From: [REDACTED]
To: LakeLothing@pins.gsi.gov.uk
Subject: Deadline 8. Response by Lowestoft Cruising Club to REP7-005: SCC responses to ABP
Date: 26 March 2019 16:21:57

I would like to respond on behalf of Lowestoft Cruising Club (LCC) via Deadline 8 to Document SCC/LLTC/EX/94: Response to ABP's Deadline 5 and Oral Submissions at 7 & 8 March 2019 Hearings (Examination Library ref. REP7-005).

**DRAWING TITLE**  
 NEW BRIDGE AREA PLANS  
 REGULATION 5(2)(o)  
 SHEET 2 OF 2

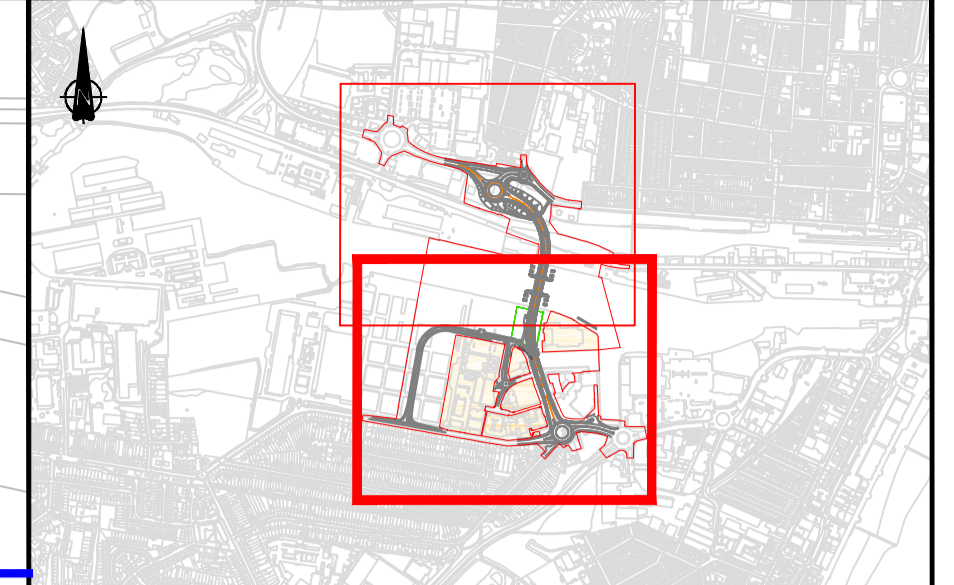
ABP's comment seems to be mainly in respect of Compulsory Acquisition issues. However, we do not understand why ABP questioned the need for the pontoon. This seems at odds with the clear request by ABP representatives at the Navigation Working Group Meetings for a waiting pontoon to be provided for safety reasons, and their suggestion of the location for the pontoon off Nexen.

We concur with the SCC 1 response. The placement of a waiting pontoon between the old and new bridges is essential to the safety and convenience of port users who get caught between the two bridges waiting for a respective scheduled bridge opening and avoiding restricted opening times. It is also a key mitigation measure in the pNRA.

SCC 2 is in response to the Compulsory Acquisition issues and not relevant to LCC, unless agreement is not reached to allow the positioning of the pontoon as planned, in which case an alternative site will need to be found.

SCC 1. The pontoon is being provided as a facility to allow recreational craft (as opposed to commercial vessels) to moor while awaiting a scheme bridge lift; the need for such a facility was identified as part of the NWG consultation and subsequently in the pNRA. The need for the facility is driven by the imposition of restrictions on bridge opening times for recreational craft. While the pontoon would be designed to accommodate small commercial vessels, the scheme of operation is such that this use is not considered likely to be necessary.
